**KIRKLEES METROPOLITAN COUNCIL
INVESTMENT & REGENERATION SERVICE**

**DELEGATED DECISION TO DETERMINE APPLICATIONS FOR
CONSENT, AGREEMENT OR APPROVAL REQUIRED BY CONDITION**

Reference No:	2025/44/91538/W
Site Address:	Jewson Property And Services Division, St Andrew's Road, Huddersfield, HD1 6PX
Description:	Discharge of details reserved by conditions 6 and 7 (drainage) on previous permission 2025/90320 for erection of extension to existing warehouse; demolition of warehouse entrance canopy and southern section of existing warehouse; demolition of existing timber storage area and erection of covered external racking area and associated works
Recommending Officer:	Danielle Cooper

2025/91538 - Jewson Property And Services Division, St Andrew's Road, Huddersfield, HD1 6PX

**TITLE**  
 Drainage Survey

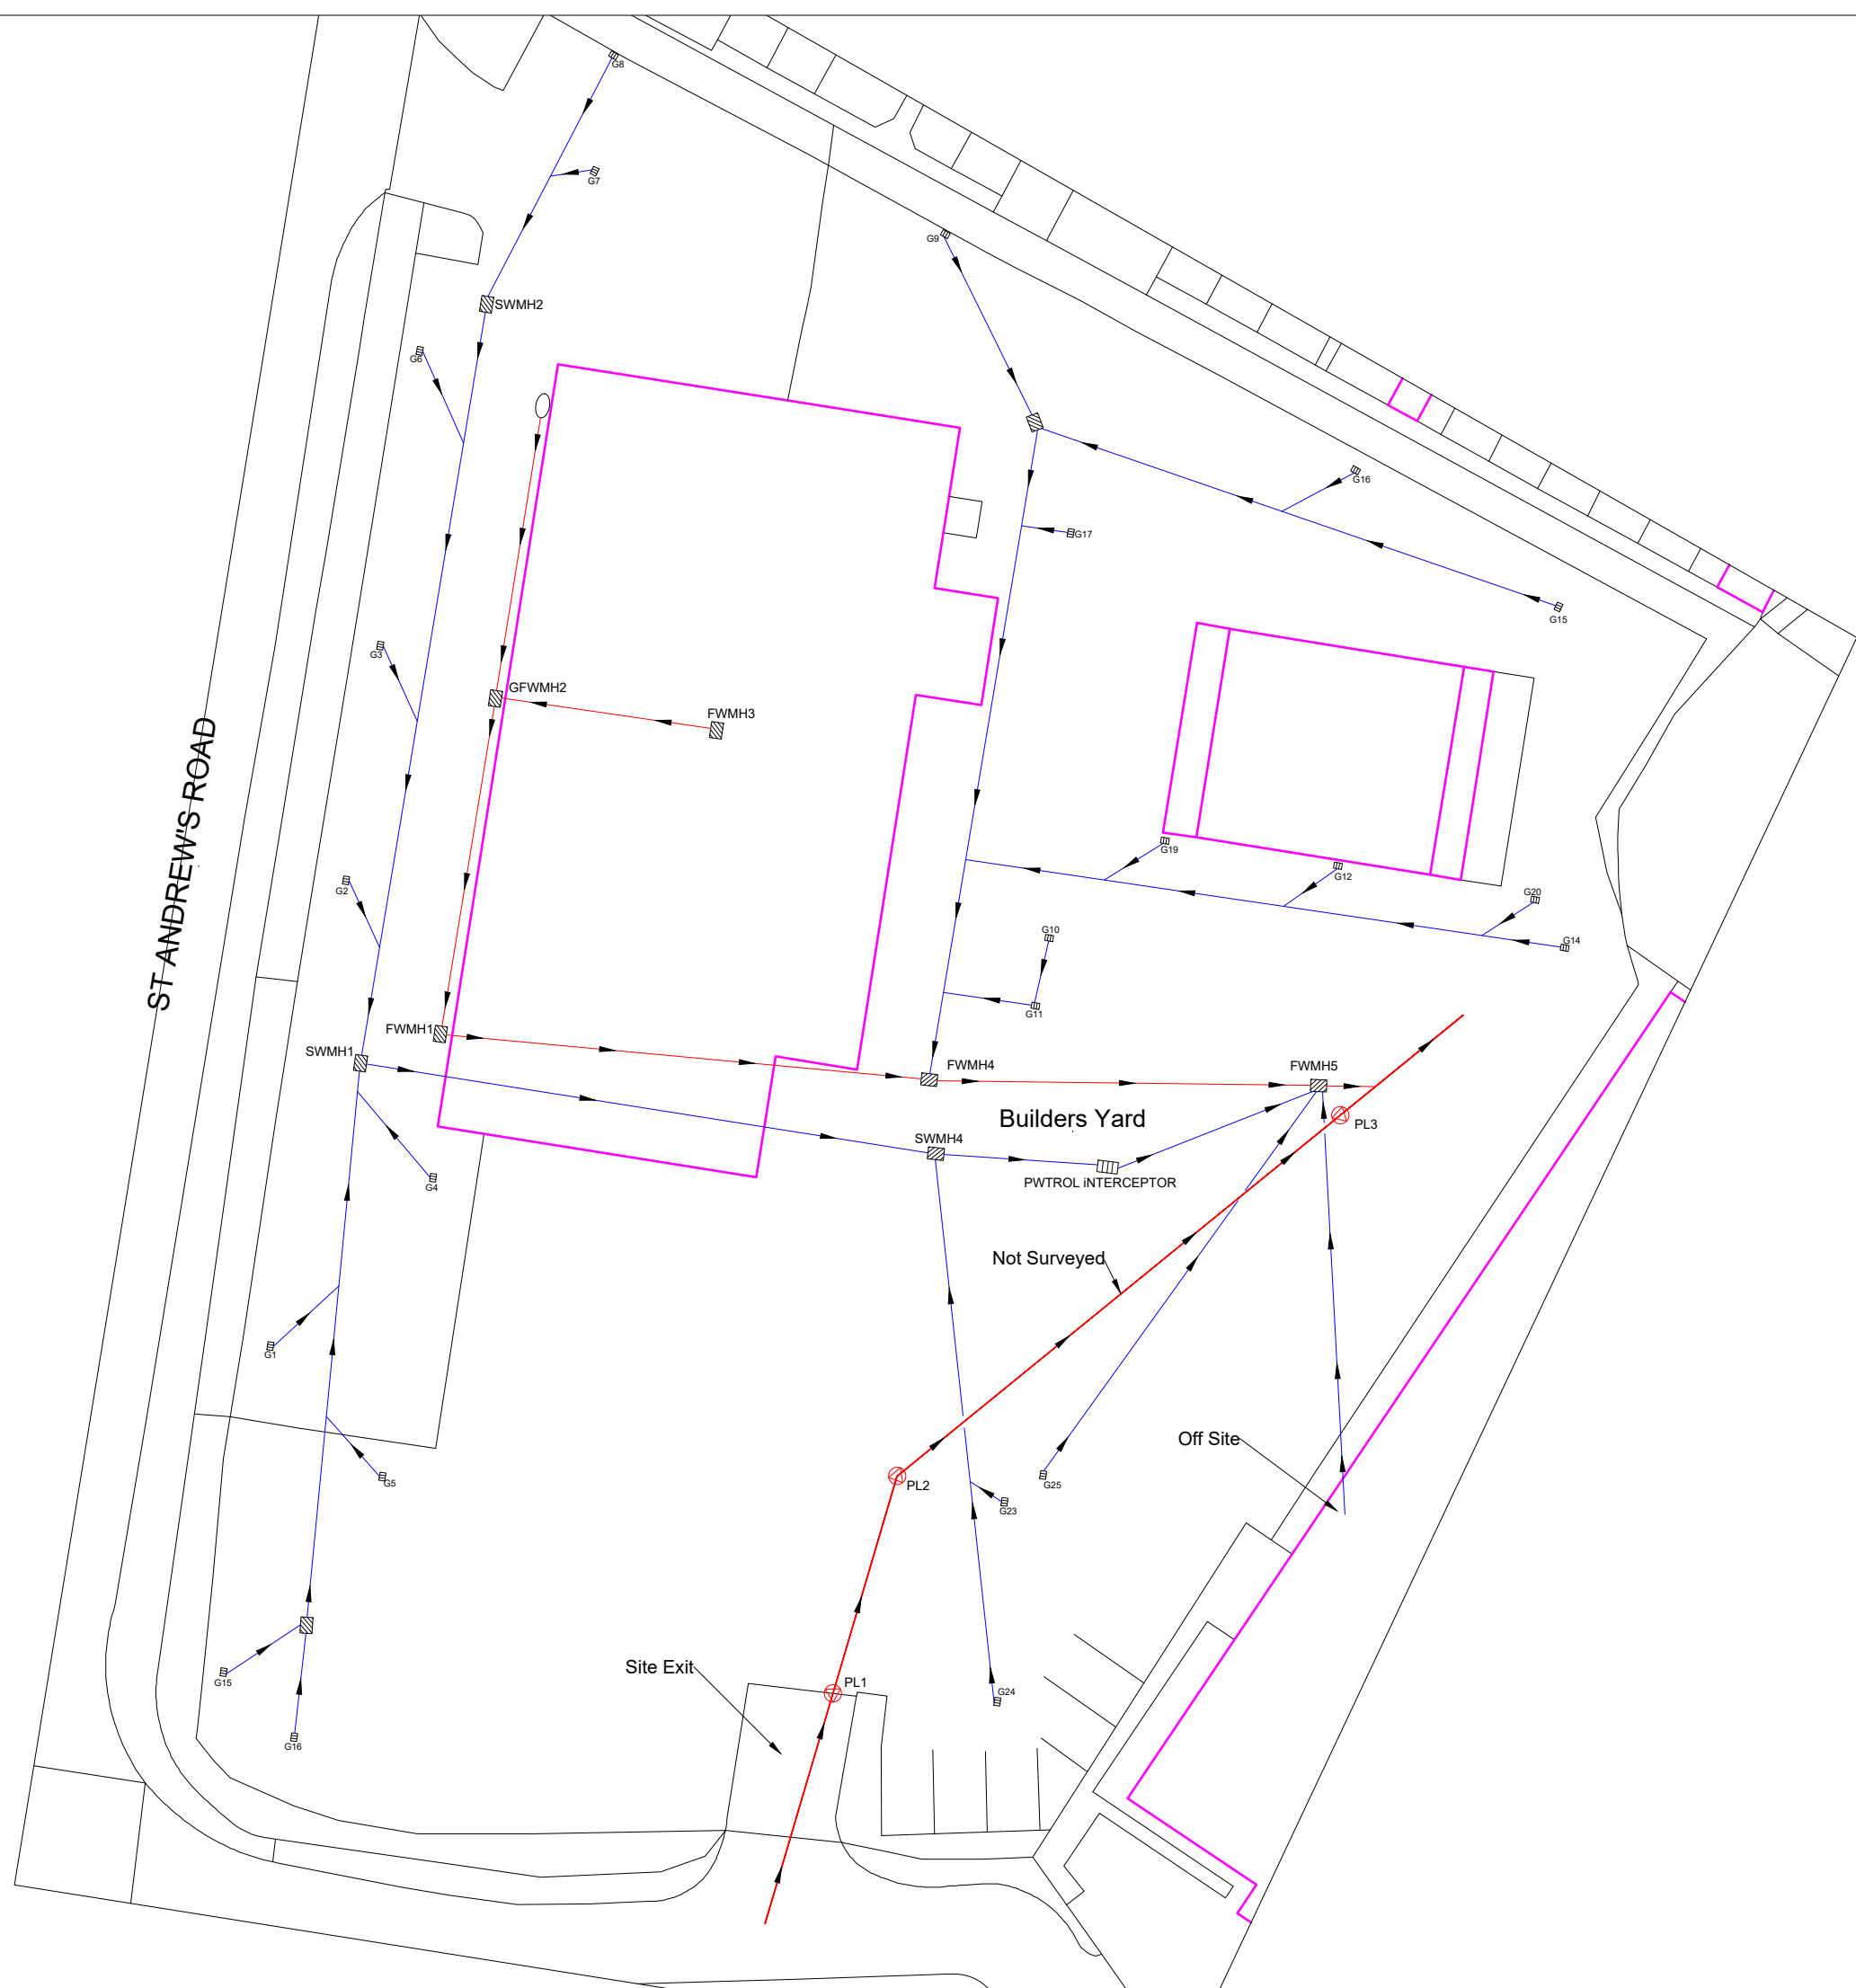
The LLFA accepts the statement in the Technical Note that an oil separator is not required as the drained area is less than 500m², and that the existing surface water drainage outfalls via a petrol interceptor as shown in the drawing titled 'Drainage Survey', ref: Jewson Huddersfield Rev O, dated 04/06/2024. Therefore condition 7 can be discharged. The scheme shall be implemented in accordance with the technical plan titled 'Drainage Survey', ref: Jewson Huddersfield Rev O, dated 04/06/2024, and thereafter retained in perpetuity.

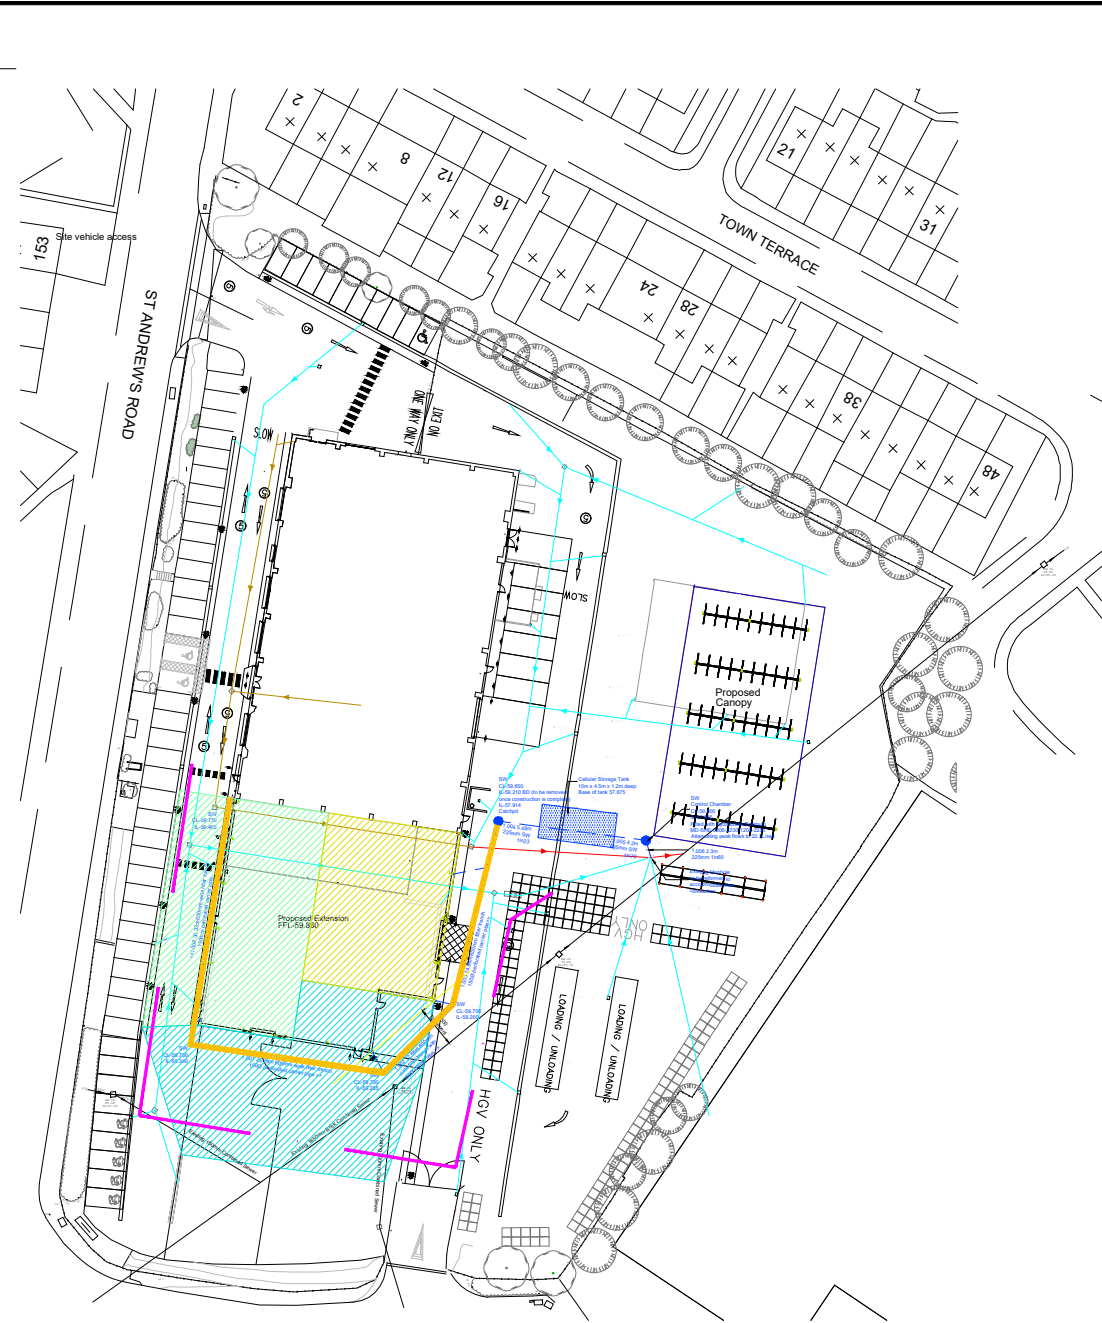
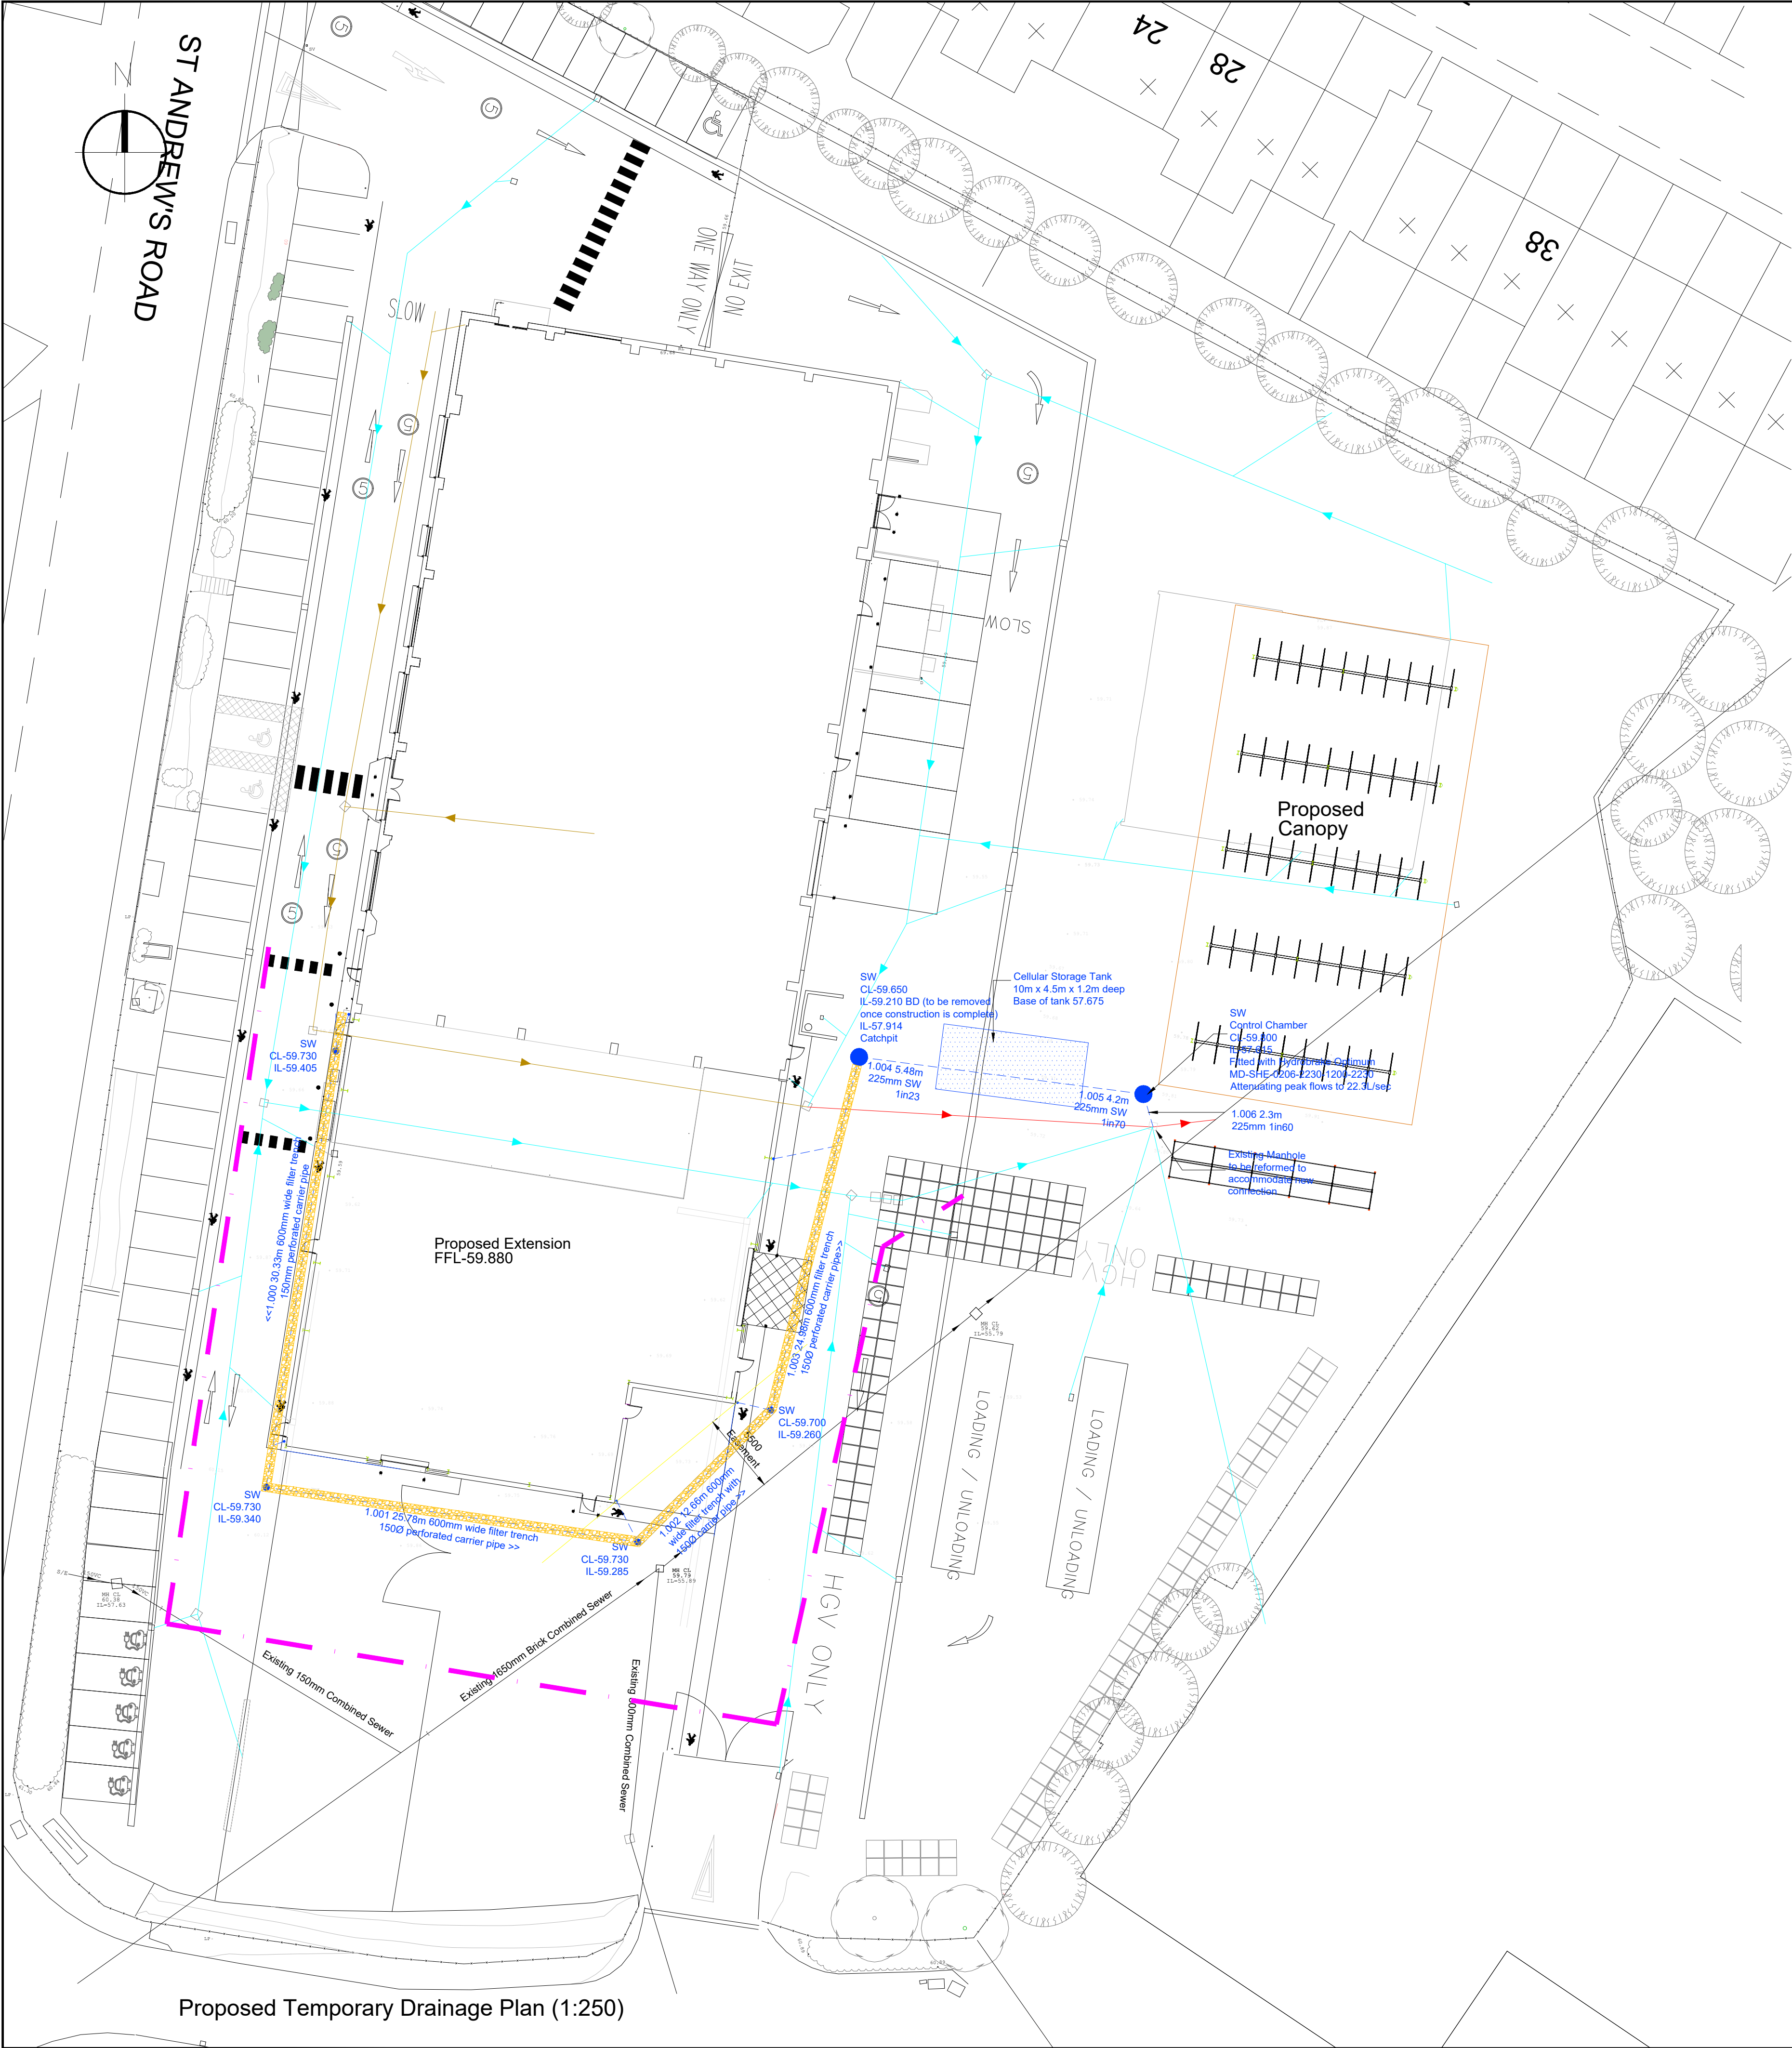
The LLFA confirms that the submitted Temporary Drainage Plan is accepted, and is adequate for the purpose of discharging the condition. The scheme shall be implemented in accordance with the approved details and retained in perpetuity.
